**From:** David Chapman  
**Sent:** 17 August 2016 13:17  
**To:** Andrew Windscheffel  
**Subject:** 45 Northaw Road East

Further to my earlier mail concerning the application for No 45 Northaw East enclosing photographs I would like the following questions to be raised at the meeting:

Front Elevation Proposed

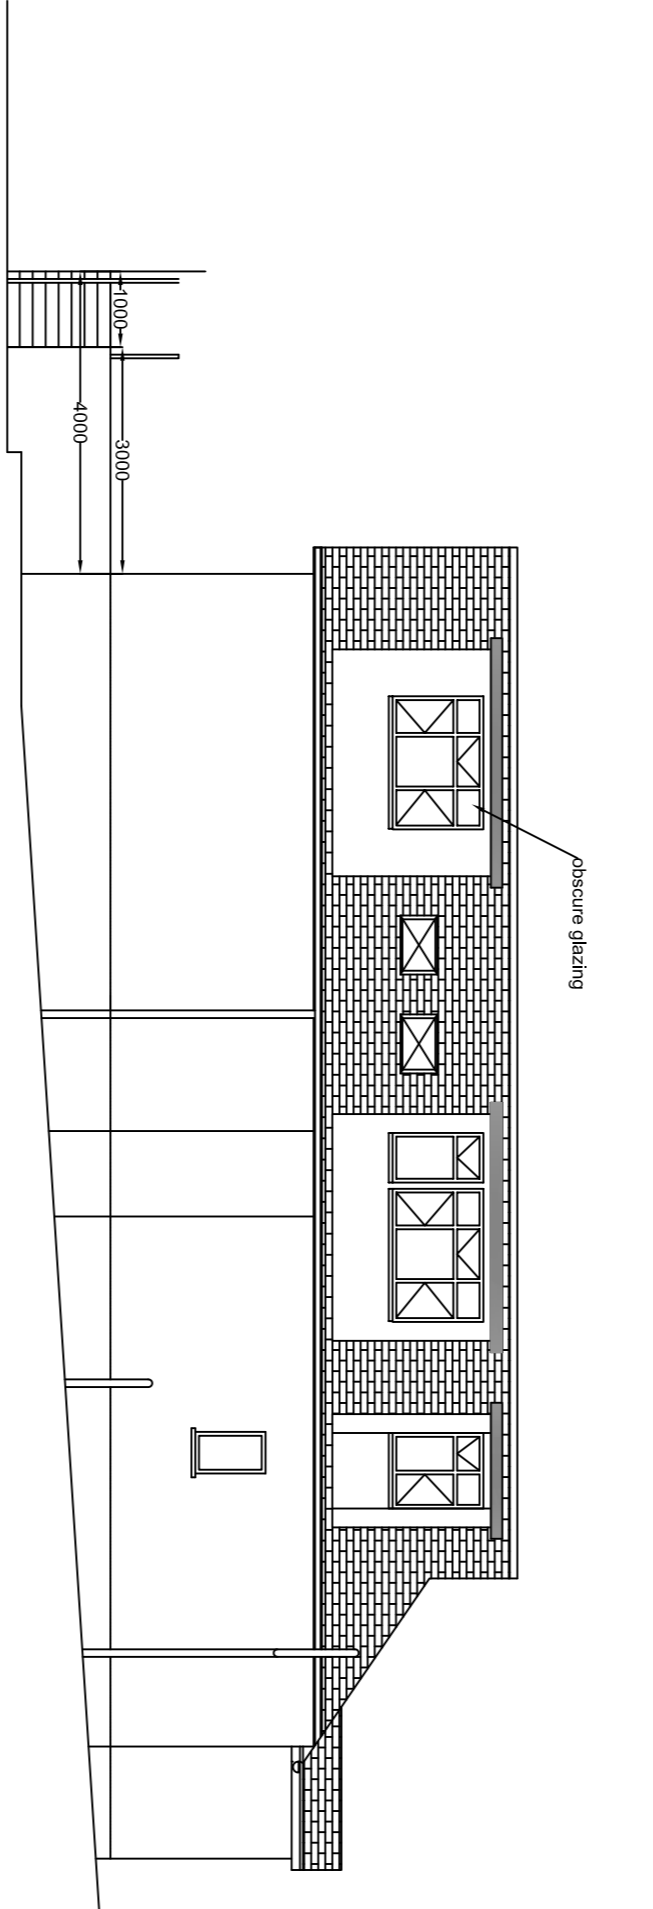
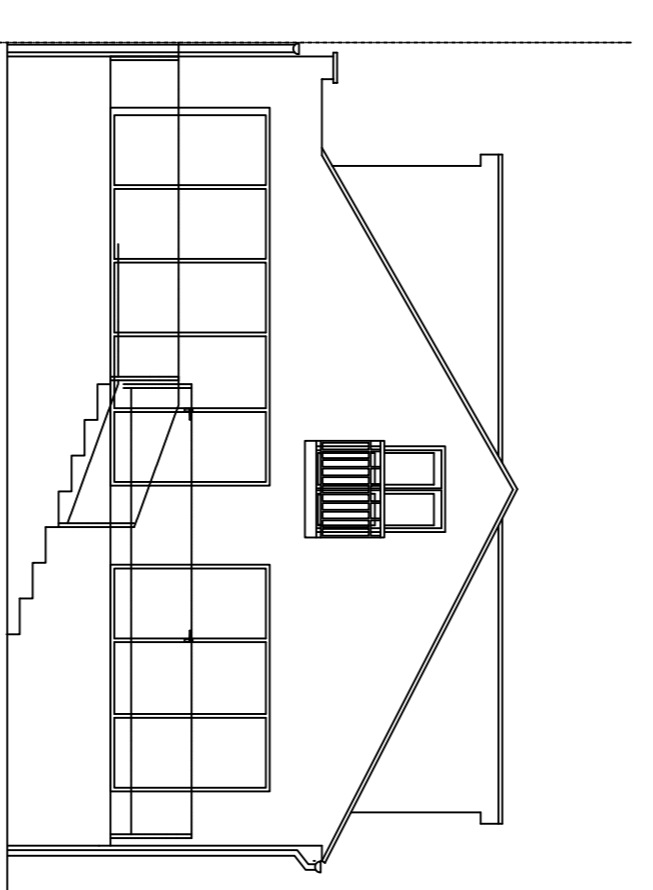
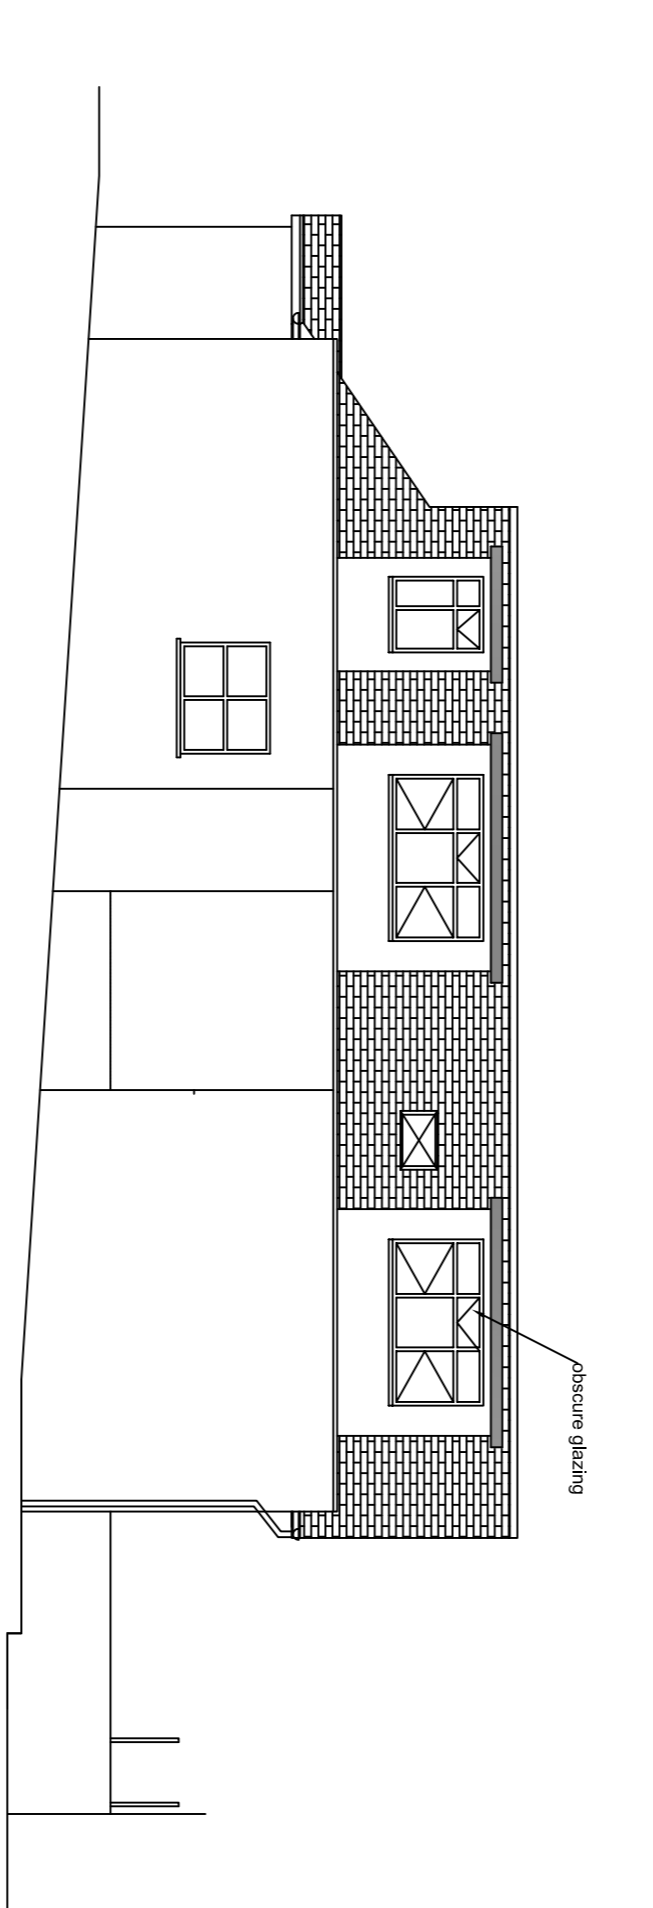
1. Is it standard practice for the planning department to except retrospective applications after the applicant has failed to comply with the original application.
2. Variation 1 - Erection of a 200mm (later it is mentioned as 400mm) high parapet wall. In fact this wall has been increased by 1.15m
3. Variation 4 - Increase in the height of the flat roof. As Variation No 1
4. Section 2 & 3 of the Agenda item 11

The original design was out of context and over whelming especially from the back (refer to photos) and the amendments just make it worse.

9.10 - Loss of light - please see photo from our bathroom. Loss of light was bad enough with original application, however the extent of the parapet wall has made it worse.
